39 Bancroft Avenue
Roseville, NSW, 2069

**Major Project: Application Number SSD-9912
Roseville College – New Sport and Wellbeing Centre**

Figure 48 Extract of shadow diagrams

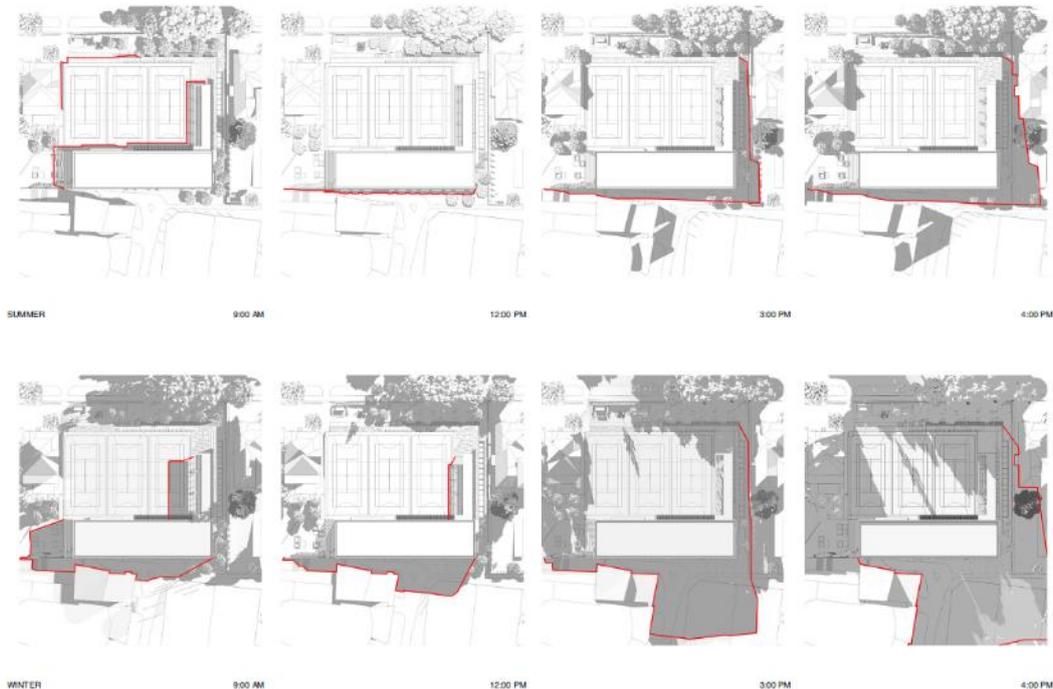
Furthermore, we note from the consultant report that there will be a substantial number of hours each day where our house and garden will be shadowed by the development, particularly during winter where the solar effect of the sun assists in warming our house.

- rejecting the application to demolish 37 Bancroft Avenue
- if 37 Bancroft Avenue is approved for demolition and inclusion in the development, the tennis court deck height should be reduced to the level of the existing 37 Bancroft tennis court (RL 82.44)
- the large building at the Southern end of the proposed tennis courts should be relocated Westwards onto land at 31-35 Bancroft Avenue

## 01 Site Plan

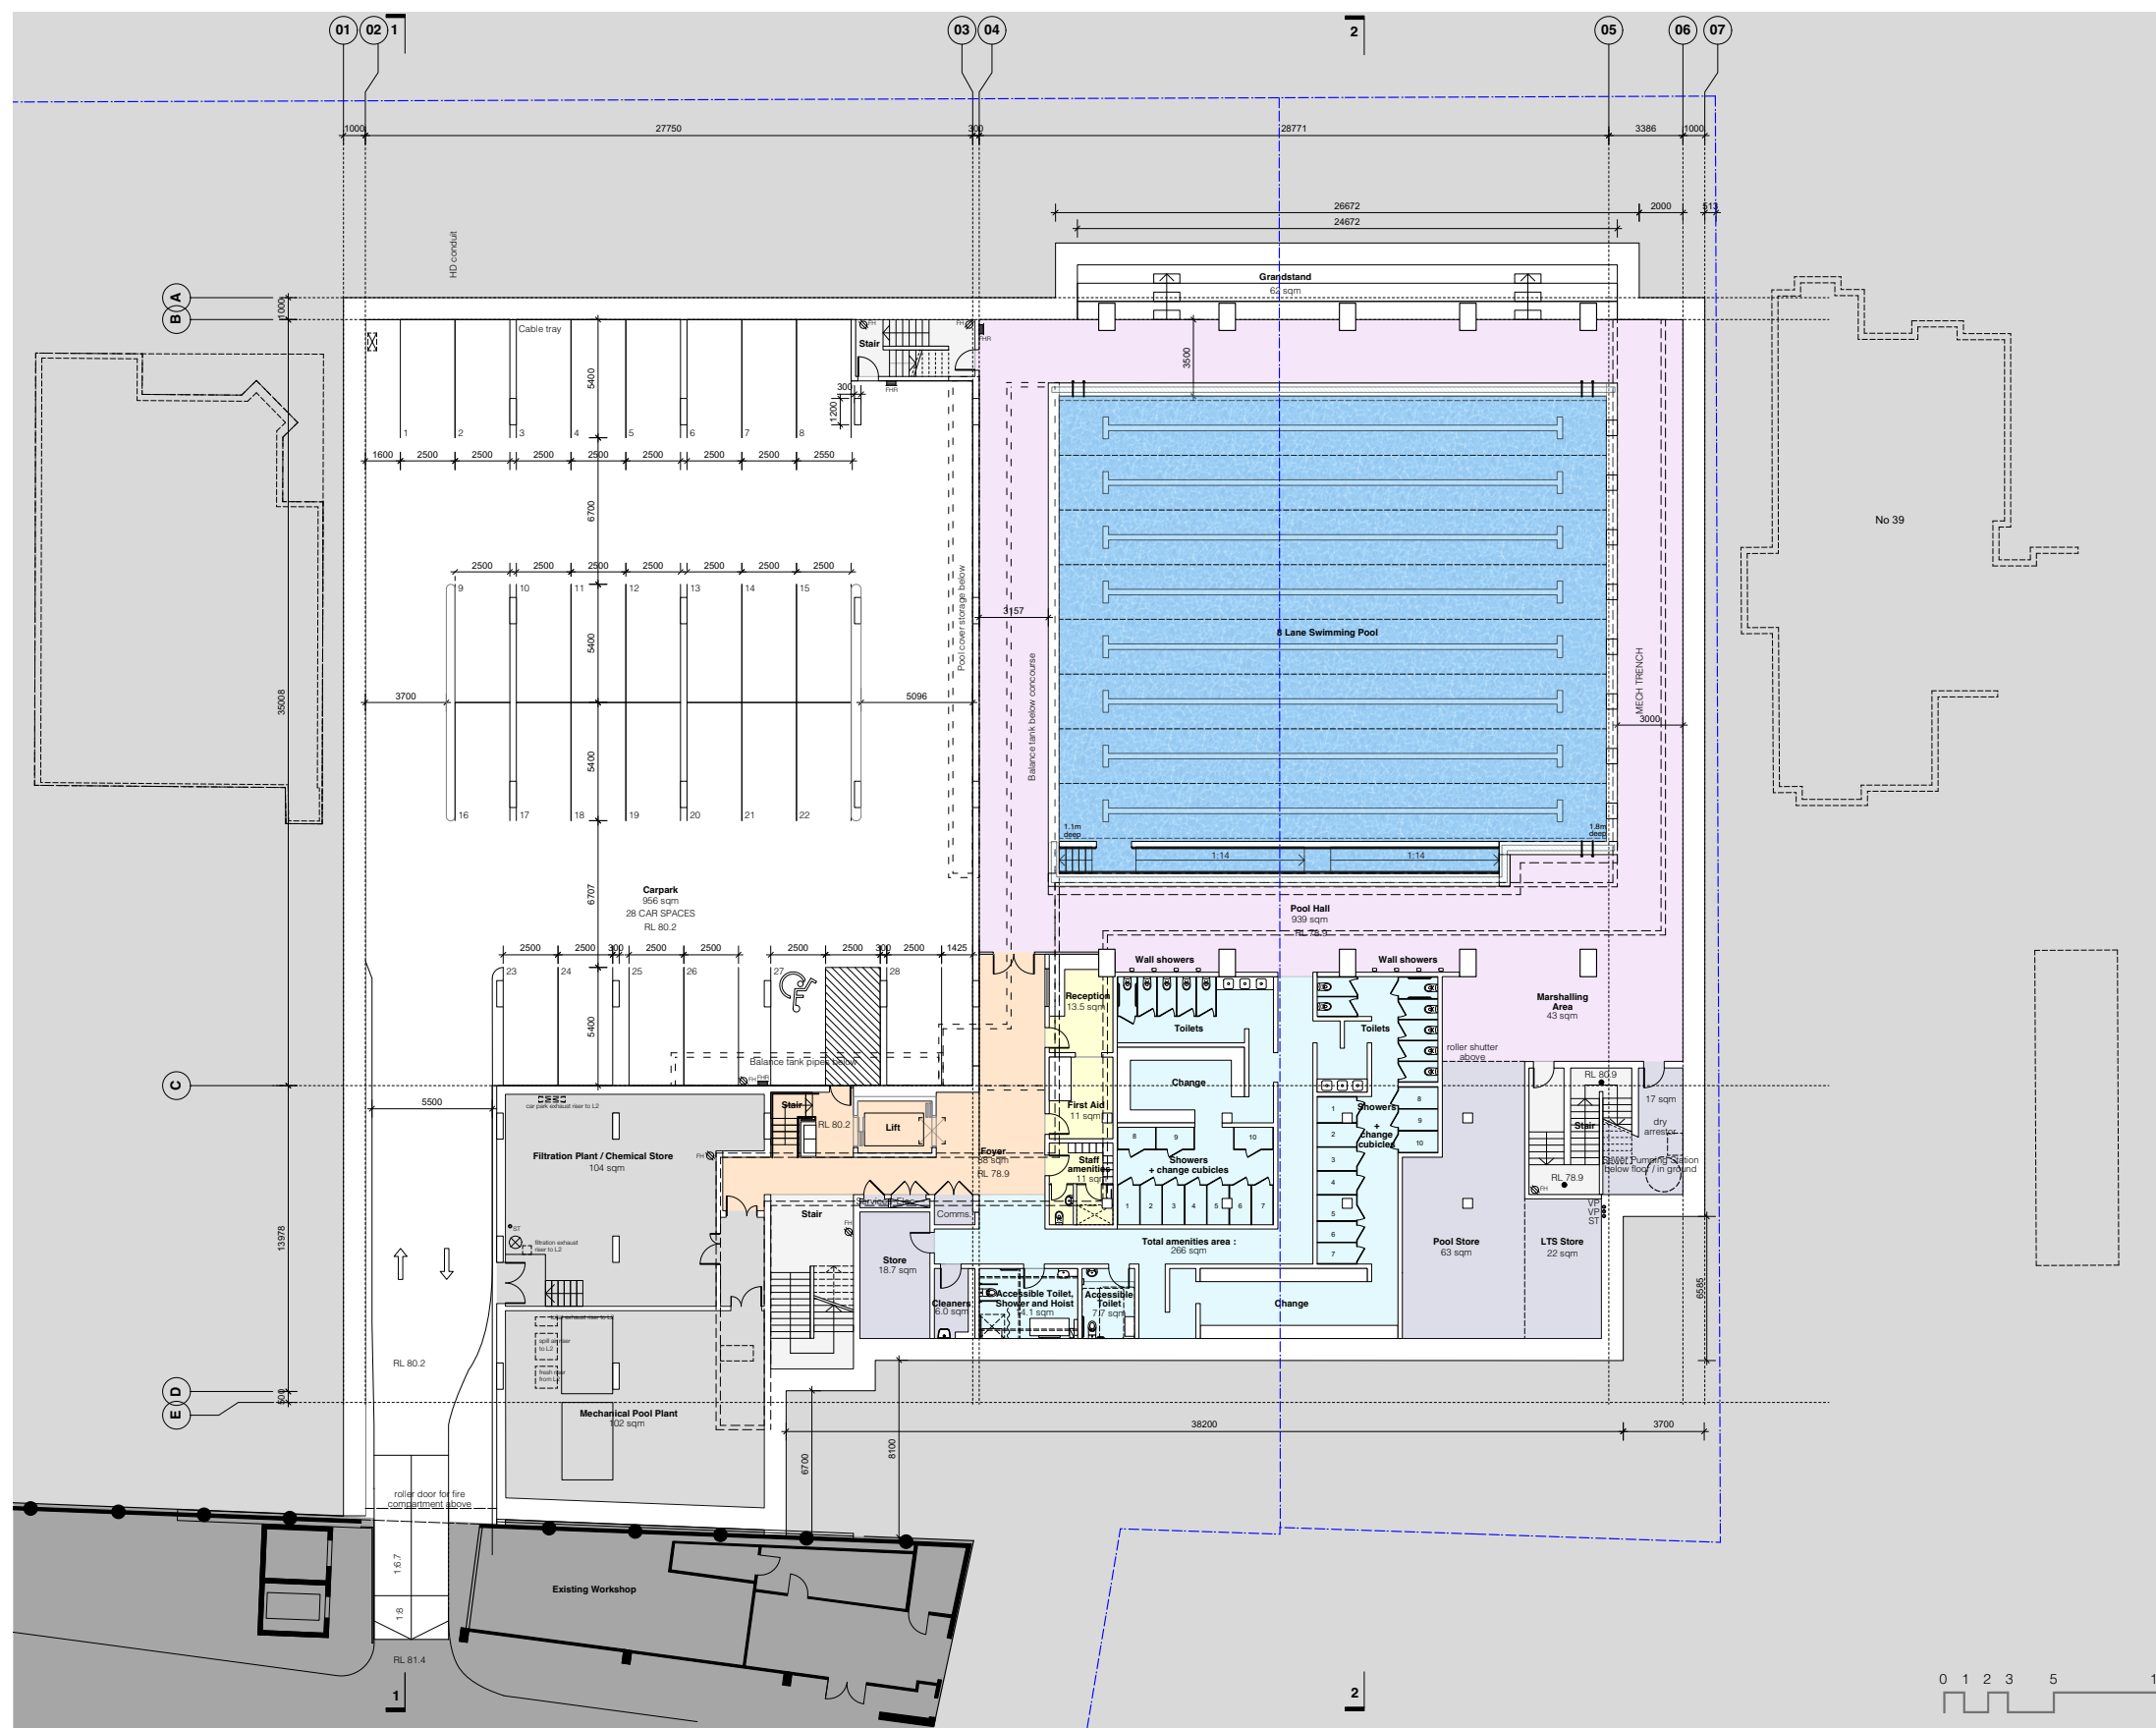
The plans provided show that the Subterranean Eastern wall of the development will be 1.0 metres from our boundary. We object to this because:

Should approval be granted to undertake the development on 37 Bancroft Avenue **we request** that the subterranean wall of the development be at least 3 metres from our boundary (which will also assist in matters related to solar access).

07  
Elevation  
East & West

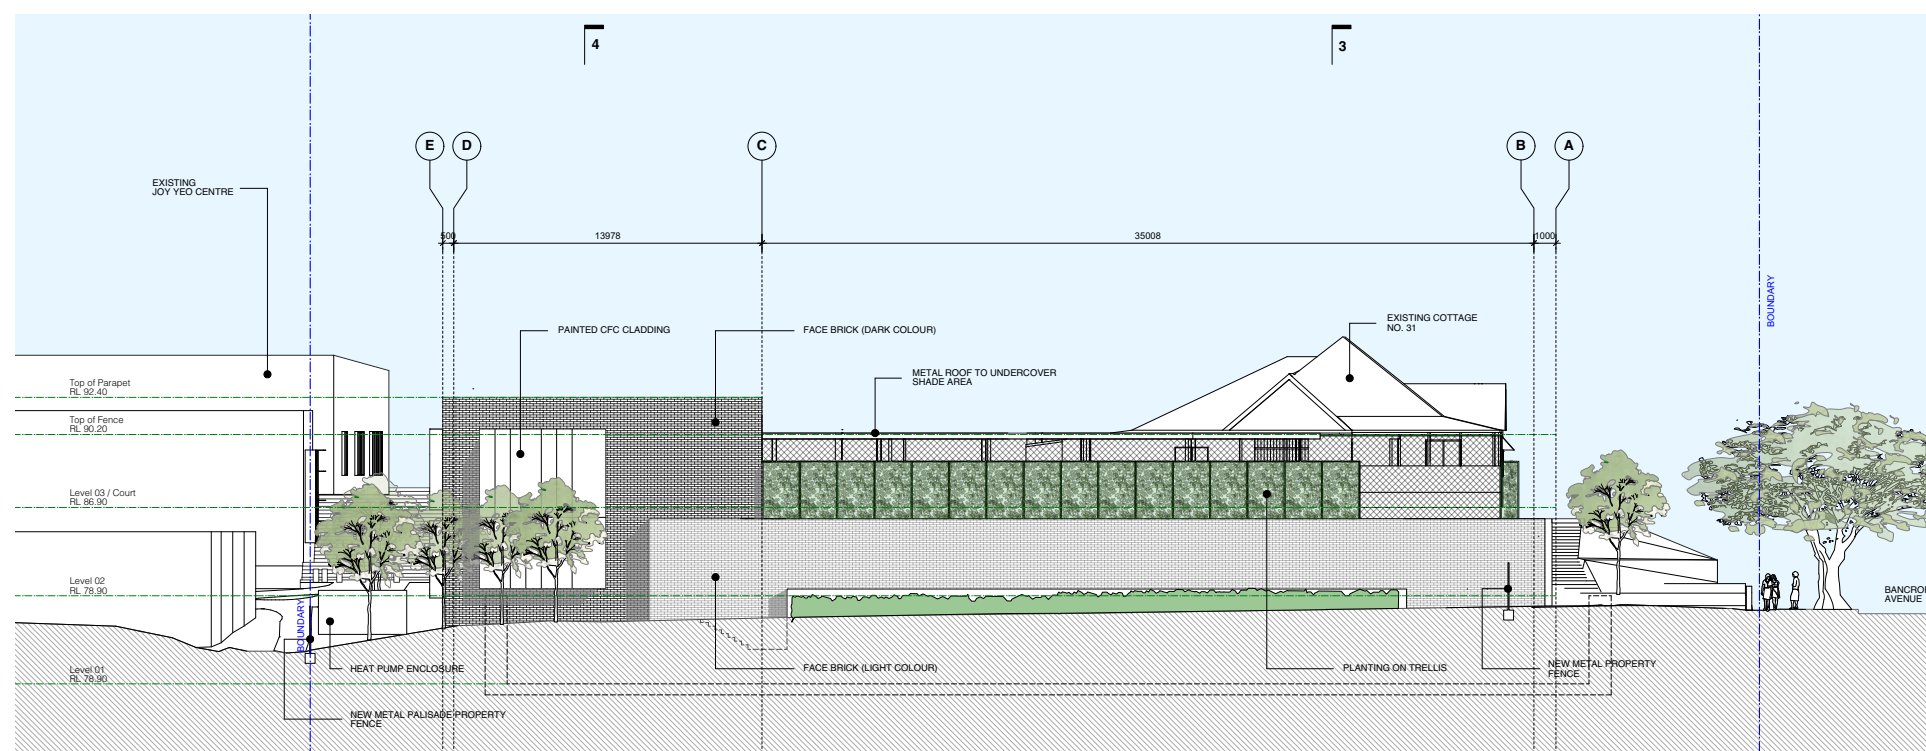
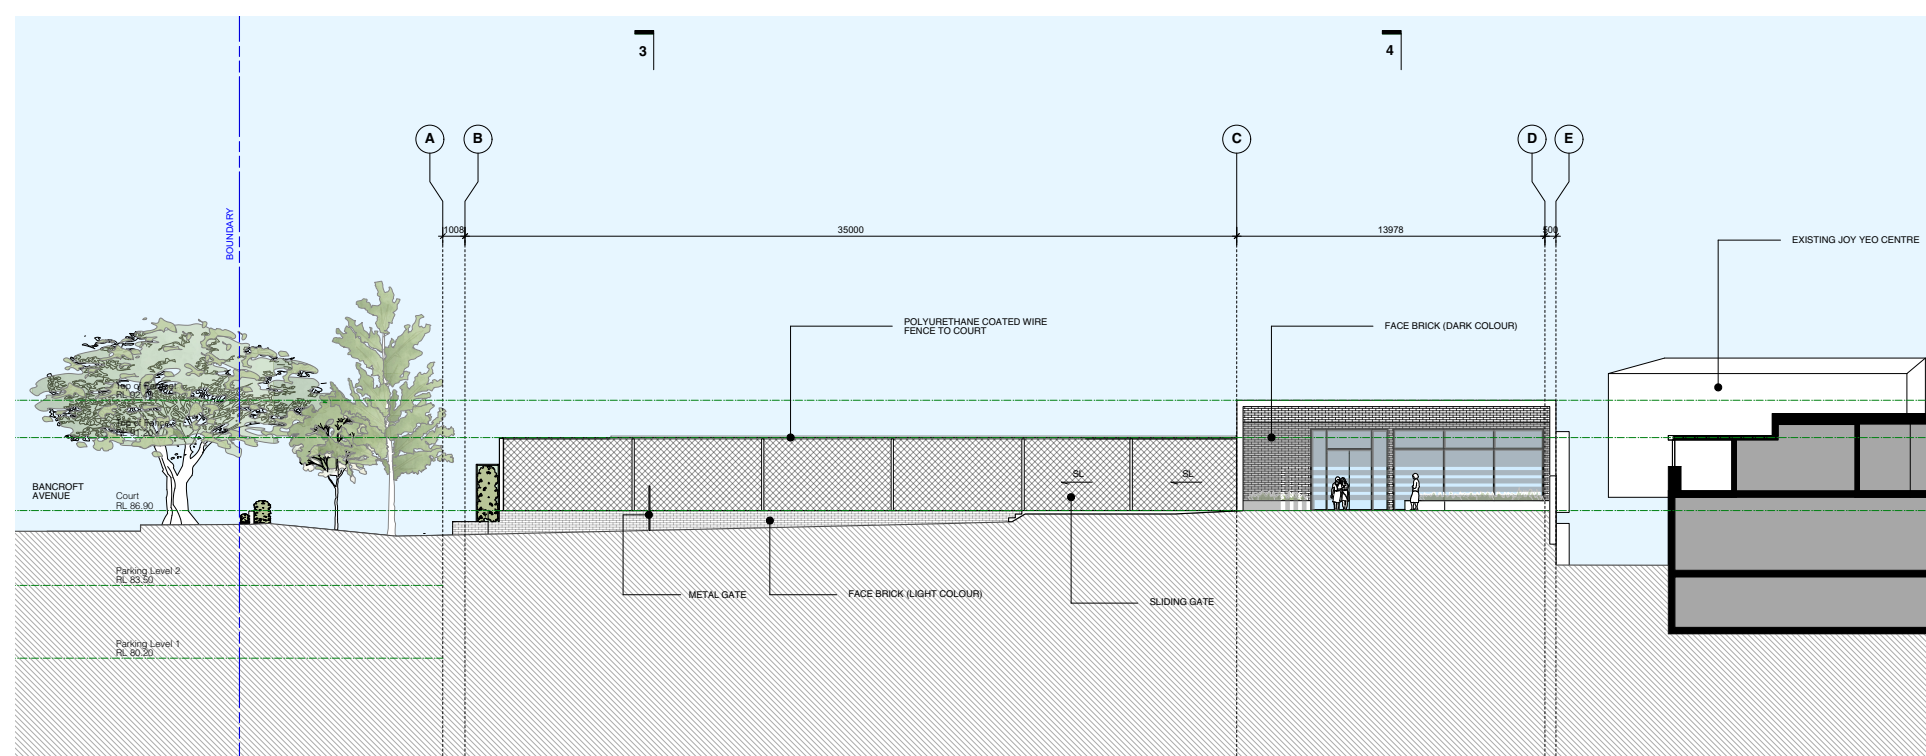
- i. from the Bancroft Avenue building line, built structures approx. 50 metres in length along our Western boundary. These structures consist of:
 - a solid wall approximately 36.5 metres in length and approximately 5 metres high, which will be topped by a 25 metre long metal awning approximately 3 metres in height, creating a total wall height of approximately 8 metres (NB the acoustic consultant has recommended that the Eastern wall of the 25 metre metal awning be filled with a solid-fill wall to lessen the effects of noise from people using the courts and awning)

- abutting the abovementioned wall, at the Southern end of the development will be a building, also facing directly onto our Western boundary. This building will be approximately 14.4 metres wide on our boundary and will rise to a height of approximately 11.5 metres above the level of our rear garden and swimming pool. This building will dominate our Western view and directly looks over our swimming pool and rear garden, depriving us of any privacy when we are outside
- ii. These elements create a monolithic structure along our Western boundary, dominating the skyline from every window on the Western side of our house, from our rear deck entertaining area, from our swimming pool and from all of our rear garden

- rejecting the application to demolish 37 Bancroft Avenue
- relocating of the Metal Awning to the Western end of the proposed tennis courts
- the large building should be relocated Westwards onto land at 33-35 Bancroft Avenue
